Review of the Liverpool Range Quarry proposal EIS

Review by

Ian Guthrie

(BArch)(retired)

Figure 1 – Key features of Liverpool Range Quarry

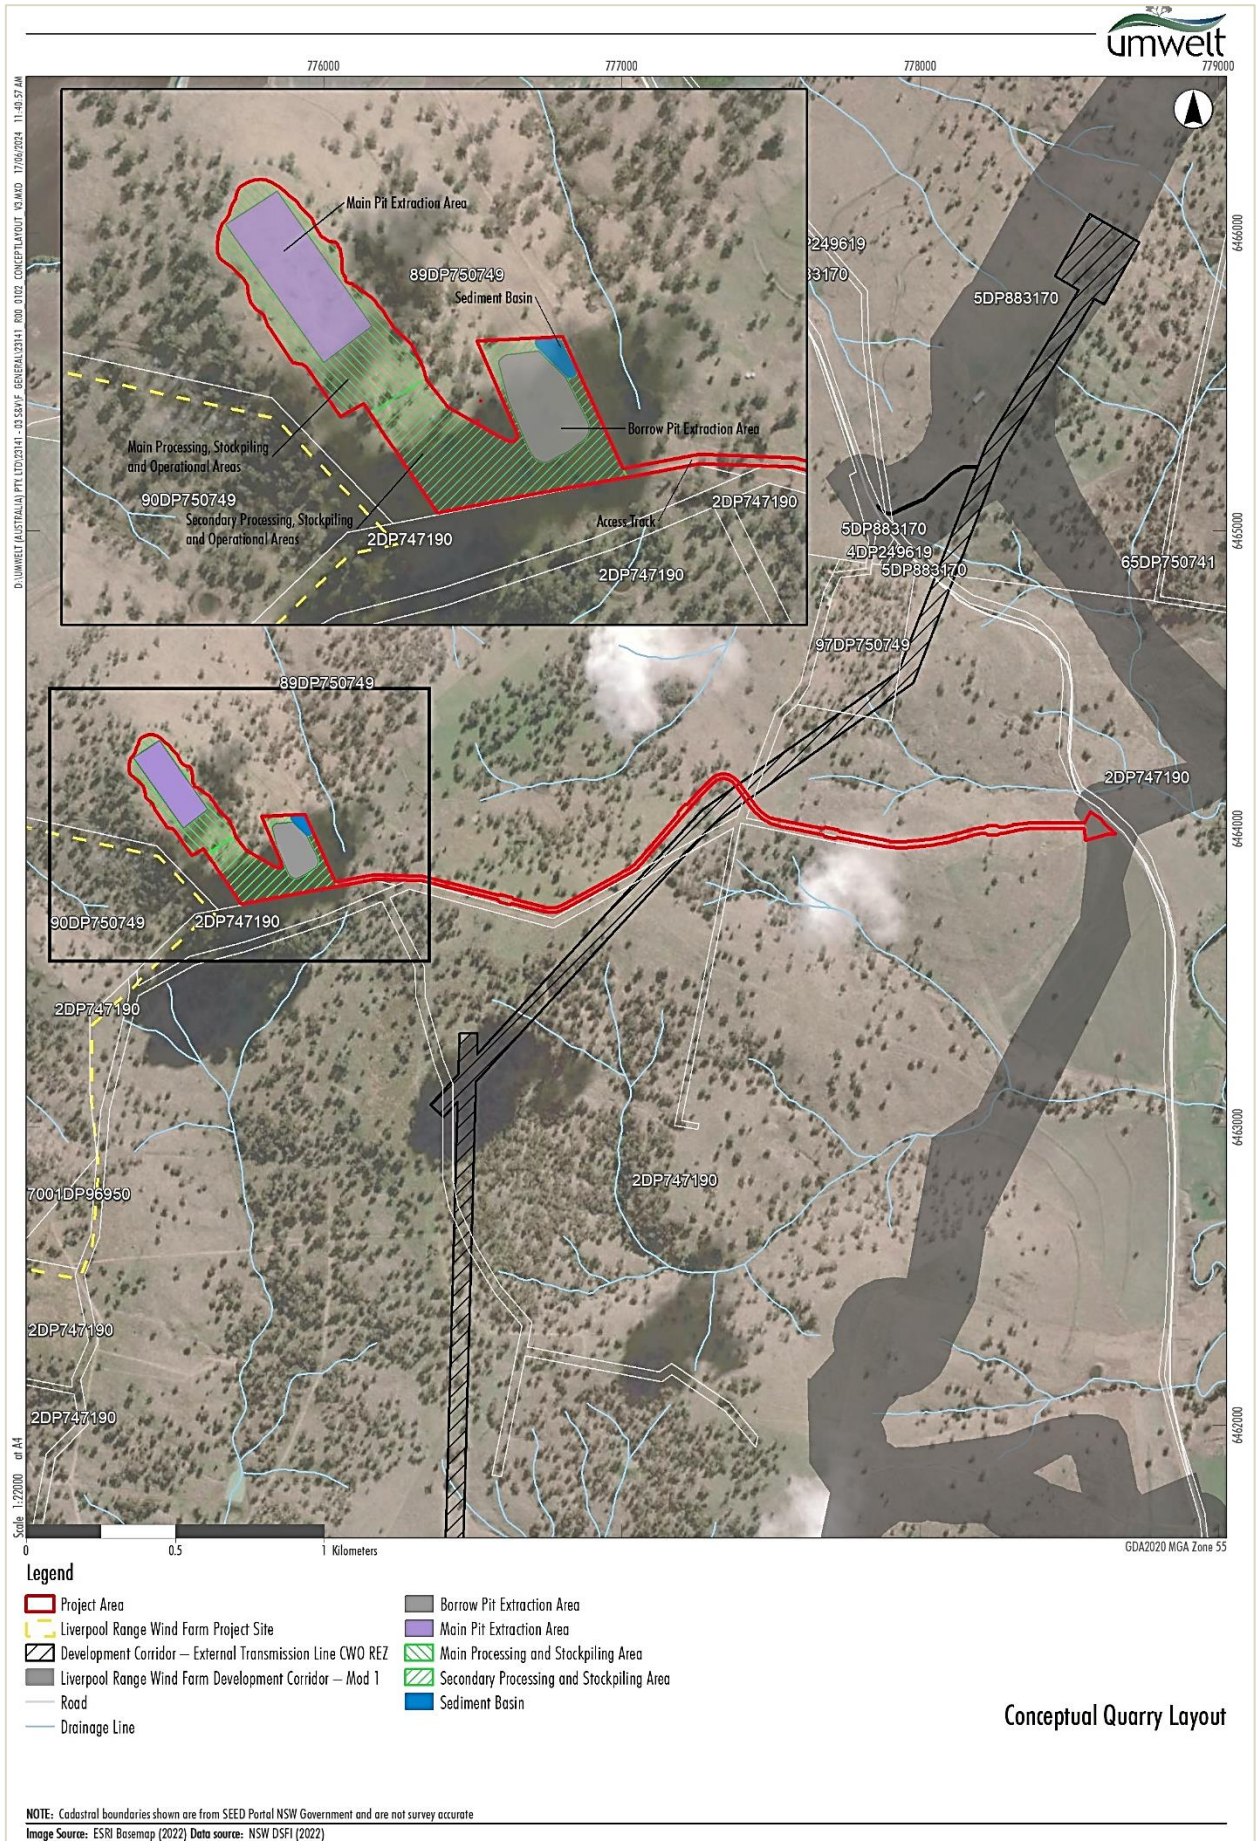
- The Quarry is set on a ridge and blasting at the edges has the potential to destabilise the narrow band of rock / earth that is not to be quarried, (see your own section drawing) how will this be managed and how will any potential 'spill' of material be managed the ensure that no stream or river is affected by the quarrying works?

- Diagram at 6.14 does not show the access paths into the main pit and does not explain how the pit will be maintained to ensure safe access to and egress from the pit. Will this pit be accessible by vehicle or foot only? Why could the south eastern end of the pit not be graded to say 15deg as part of the extraction process; the existing natural contours would assist this option? This would allow for greater potential for productive reuse of the pit!
